KIRKLEES METROPOLITAN COUNCIL INVESTMENT & REGENERATION SERVICE

DELEGATED DECISION TO DETERMINE PLANNING APPLICATIONS

Reference No:	2023/62/91964/E
Site Address:	191, Drub Lane, Drub, Cleckheaton, BD19 4BZ
Description:	Erection of extensions and alterations
Recommending Officer:	Jennifer Booth

DECISION – CONDITIONAL FULL PERMISSION

Title: **Proposed Elevations, with Existing**
Elevation Overlayed

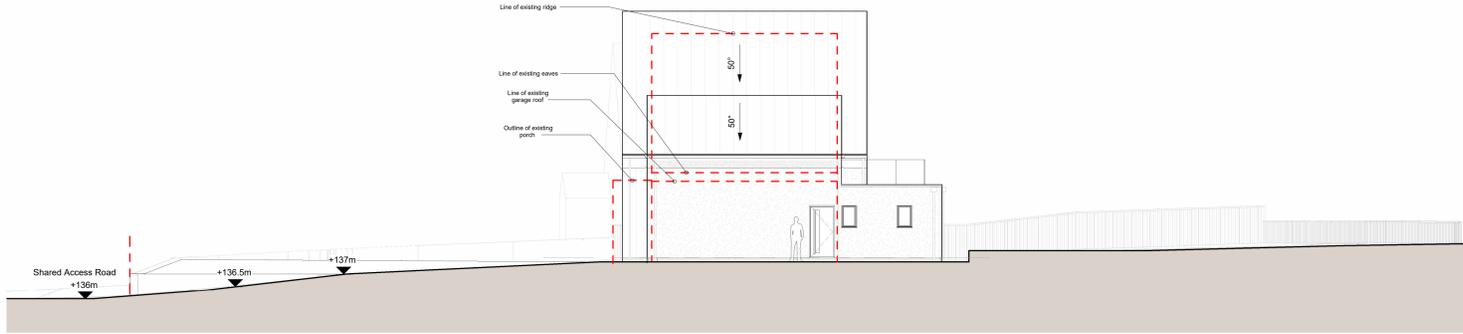
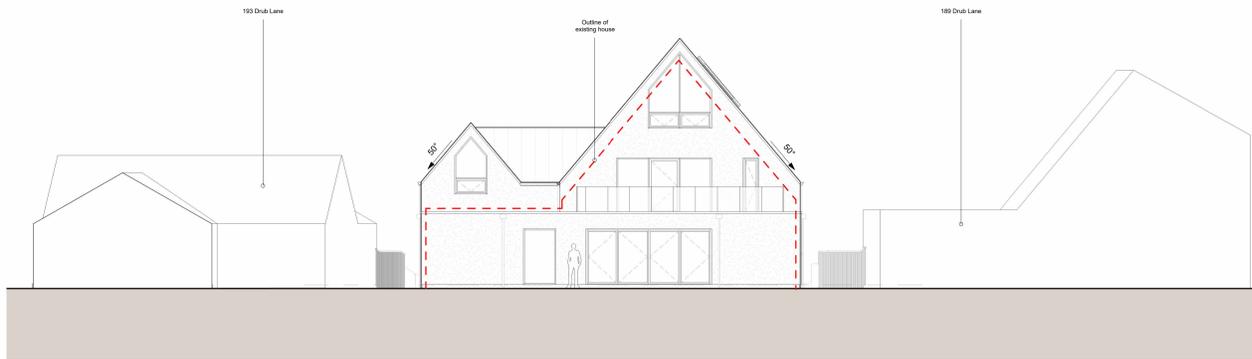
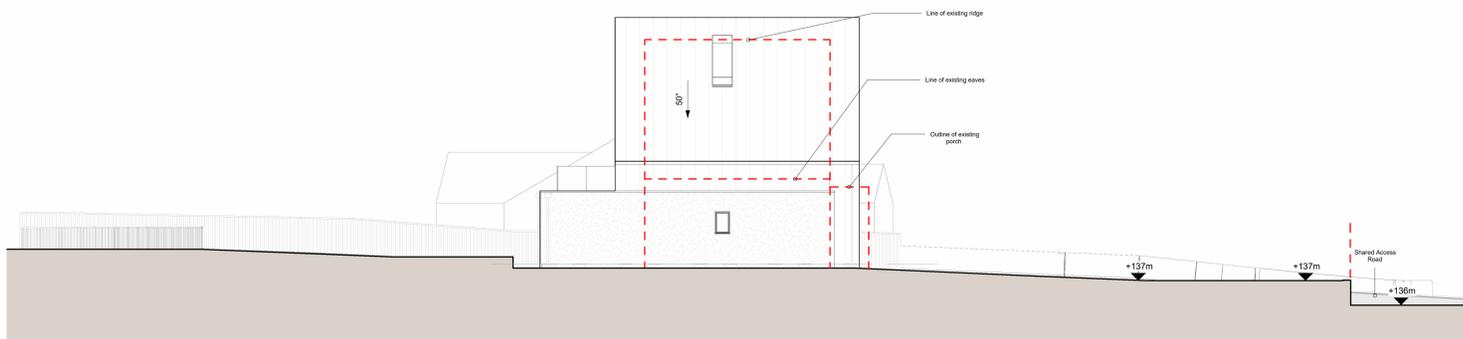
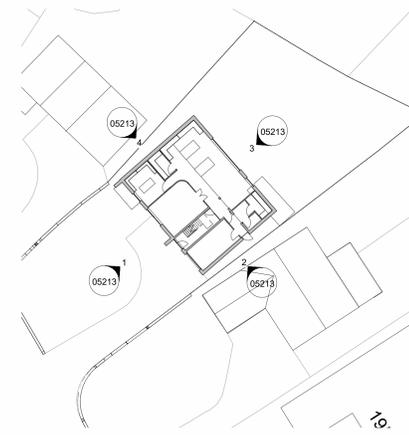
The submitted plans include an increase in the height of the eaves from 3.3m to 4.2m and an increase of the apex from 9.15 to 10m.

The existing garage is positioned close to the shared boundary with the adjacent property to the southeast. It was noted on the site visit that there is a window in the side elevation of the neighbouring property. The proposals would replace the garage with a storey and a half extension. Whilst the structure would be higher than the garage, the increase would be limited and as such would not increase the impacts over the relationship which already exists. The rear extension would align with the rear of the neighbouring

property and as such would be unlikely to result in any significant impact on the amenities of the occupiers of the adjacent dwelling. The balcony element would be set back from this neighbour and would not result in any materially detrimental overlooking.

Title: Proposed GA Plans

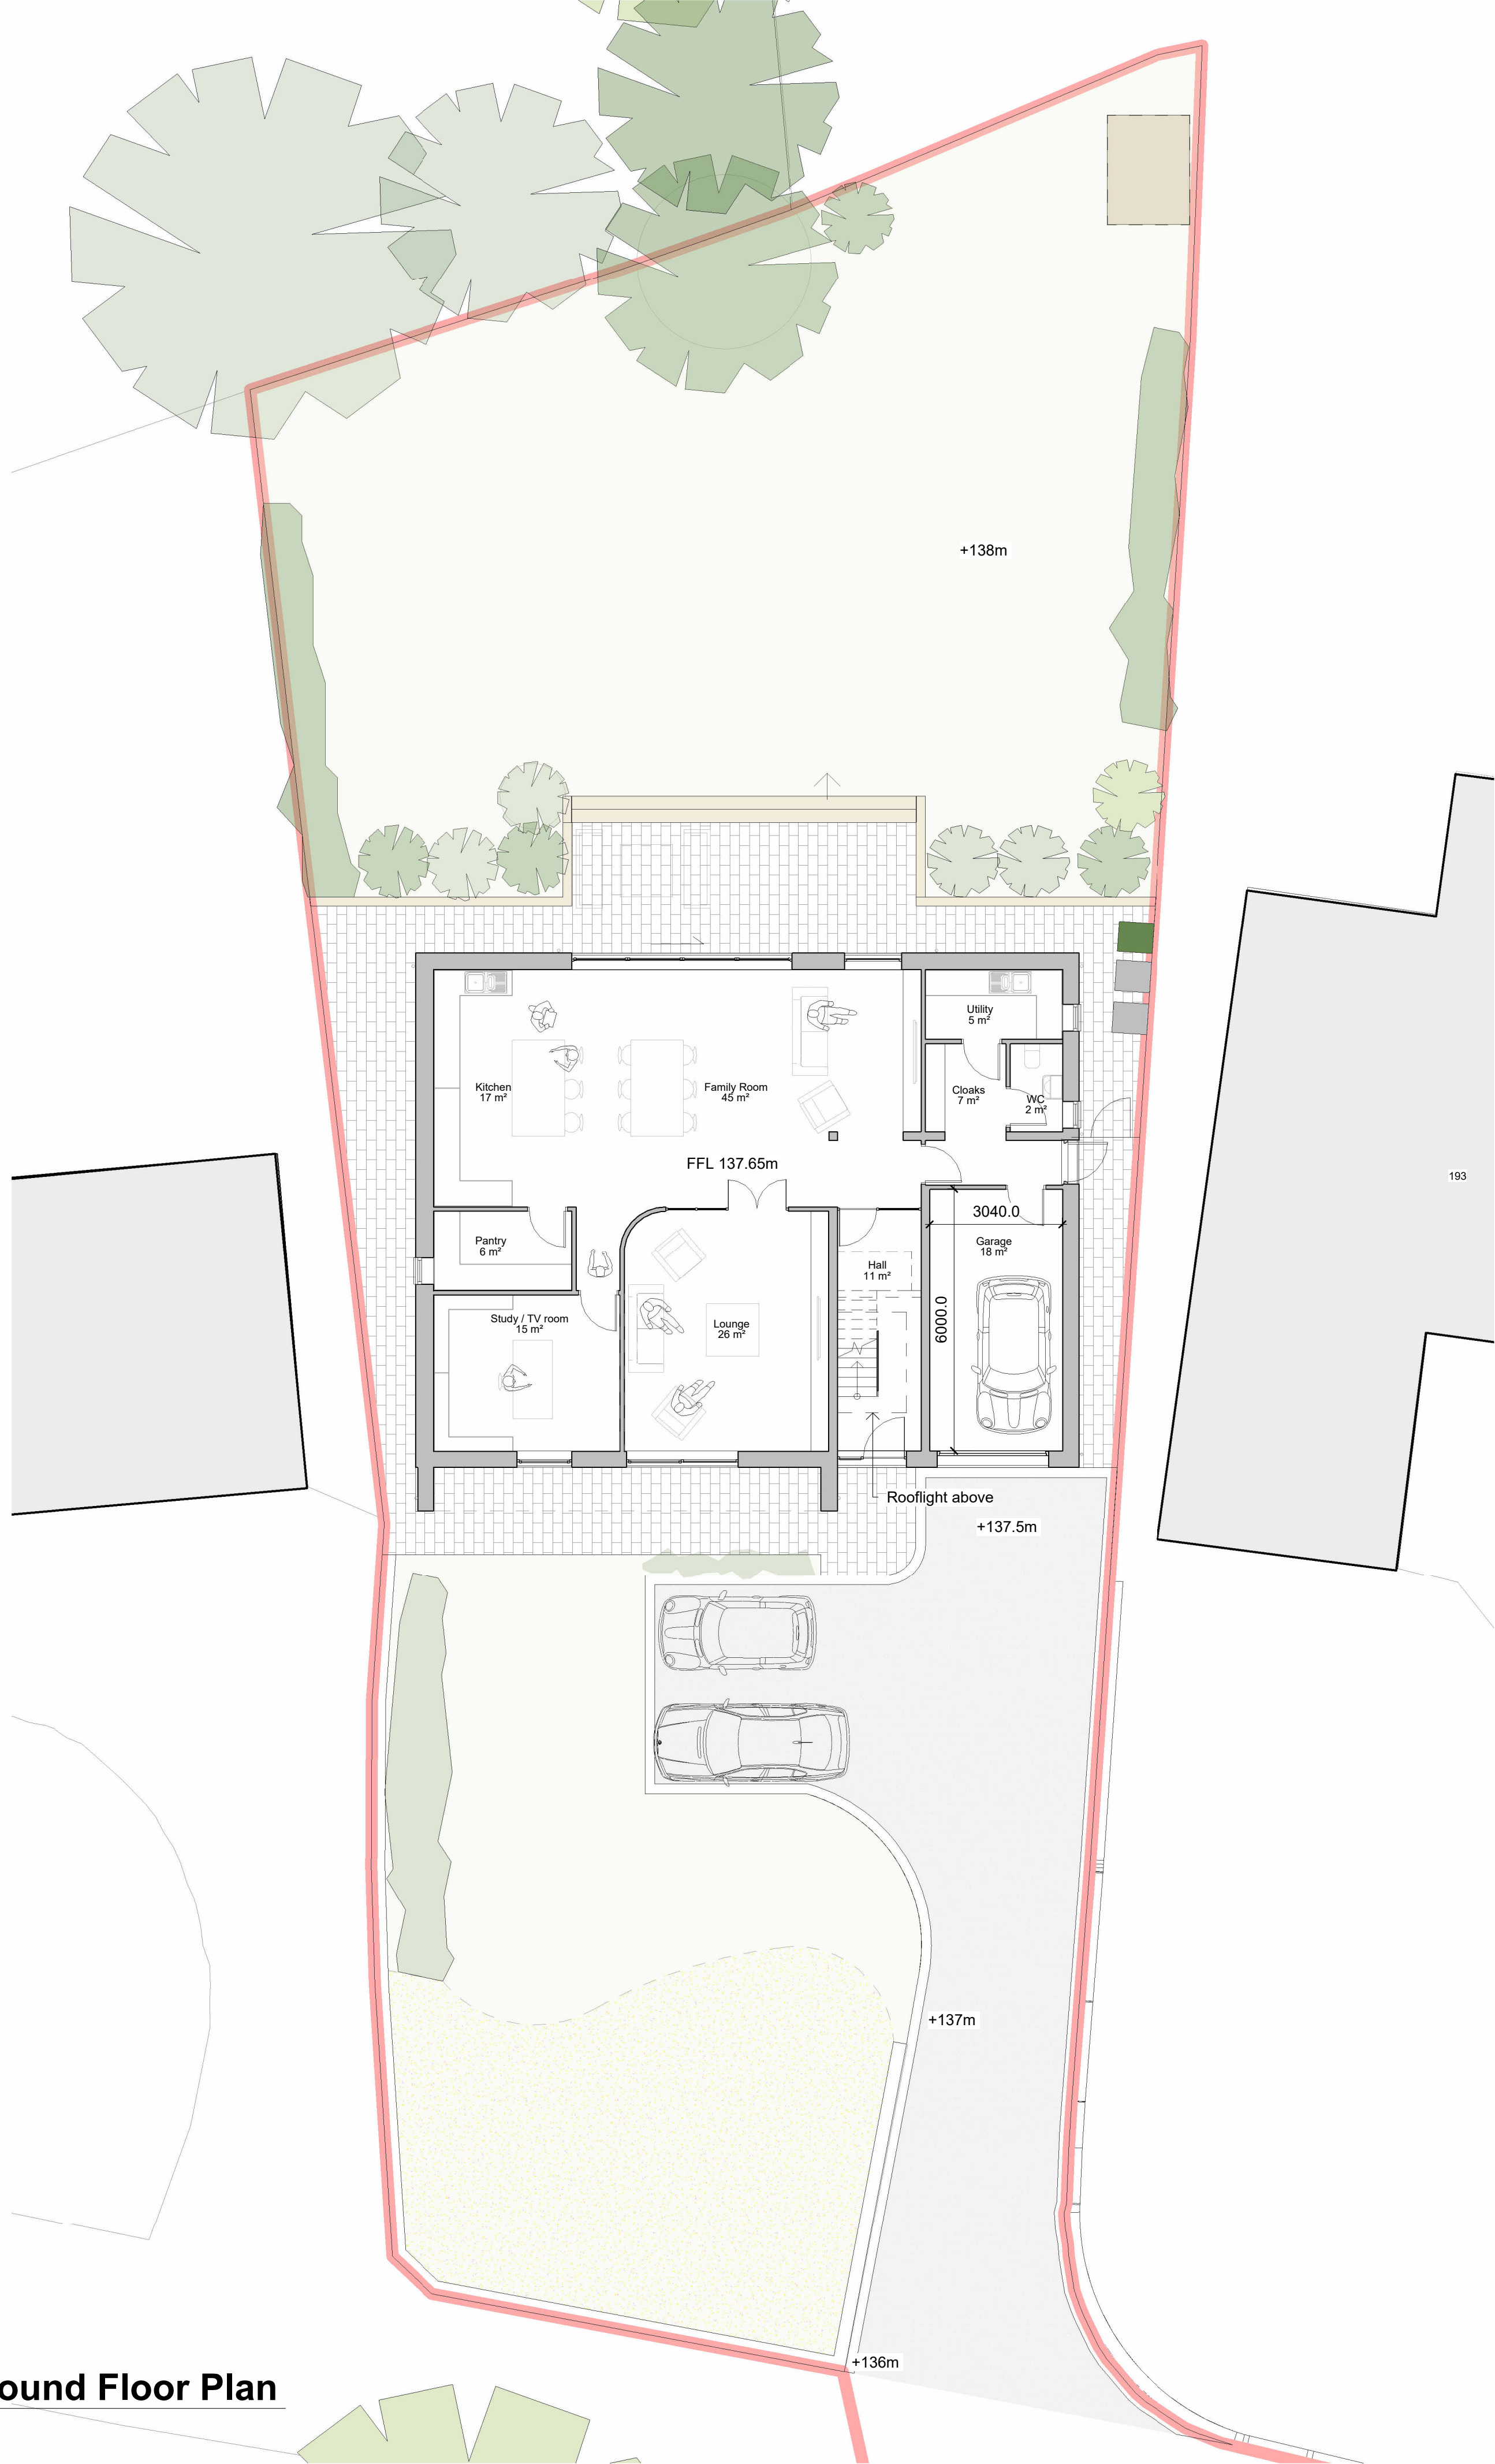
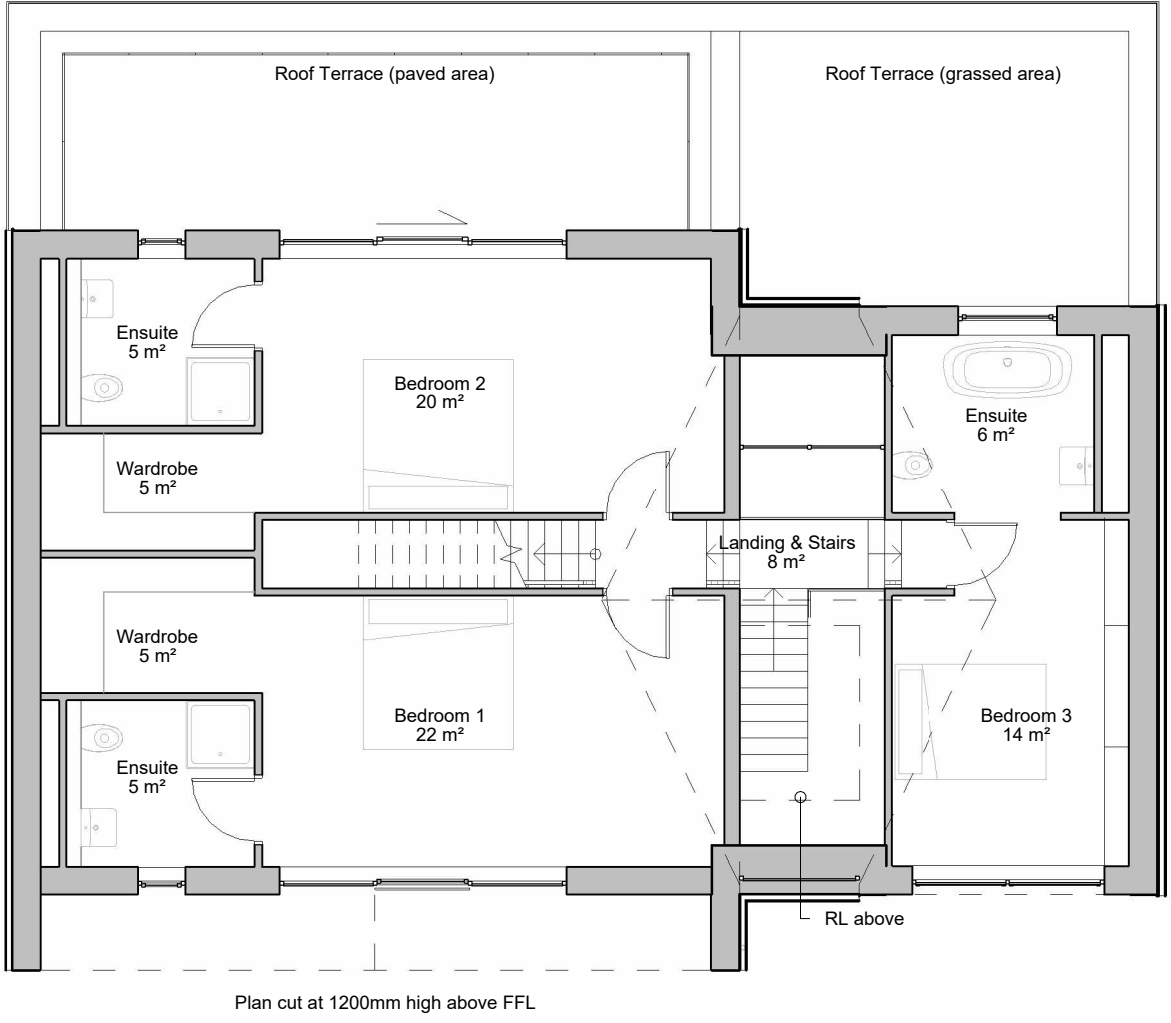
The side extension would replace the existing flat roofed garage with a width of 5.5m, extending the full depth of the dwelling and 3m beyond the rear wall. The extension across the rear elevation of the dwelling, single storey with a balcony over.

The extension to the rear would project 2.9m from the original rear wall of the dwelling, retaining a sizeable amenity space and proposed to be constructed using materials and fenestration in keeping with the overall modernisation of the property. The rear extension is therefore considered to be acceptable in terms of visual amenity.

The balcony is limited in terms of its scale and would be in keeping with the overall design and appearance of the proposals. The balcony is therefore considered to be acceptable in terms of visual amenity.

The proposals will result in some intensification of the domestic use. However, the plans provide a parking space within the garage and two spaces on the drive to the front of the dwelling which is considered to represent a sufficient provision. Bin storage for the dwelling is shown on plan as being to the rear. As such the scheme would not represent any additional harm in terms of highway safety and as such complies with Policy LP22 of the Kirklees Local Plan along with Key Design Principles 15 & 16 of the House Extension & Alterations SPD.

To ensure privacy with the adjacent 189 Drub Lane, it is considered to be reasonable to include a condition for a 1.8m privacy screen along the side of the balcony.

4. Notwithstanding the submitted plans, an obscurely grazed privacy screen, 1.8 metres in height, shall be erected along the side of the balcony hereby approved adjacent to the neighbouring 189 Drub Lane to a minimum privacy level 4 or equivalent and shall thereafter be retained.
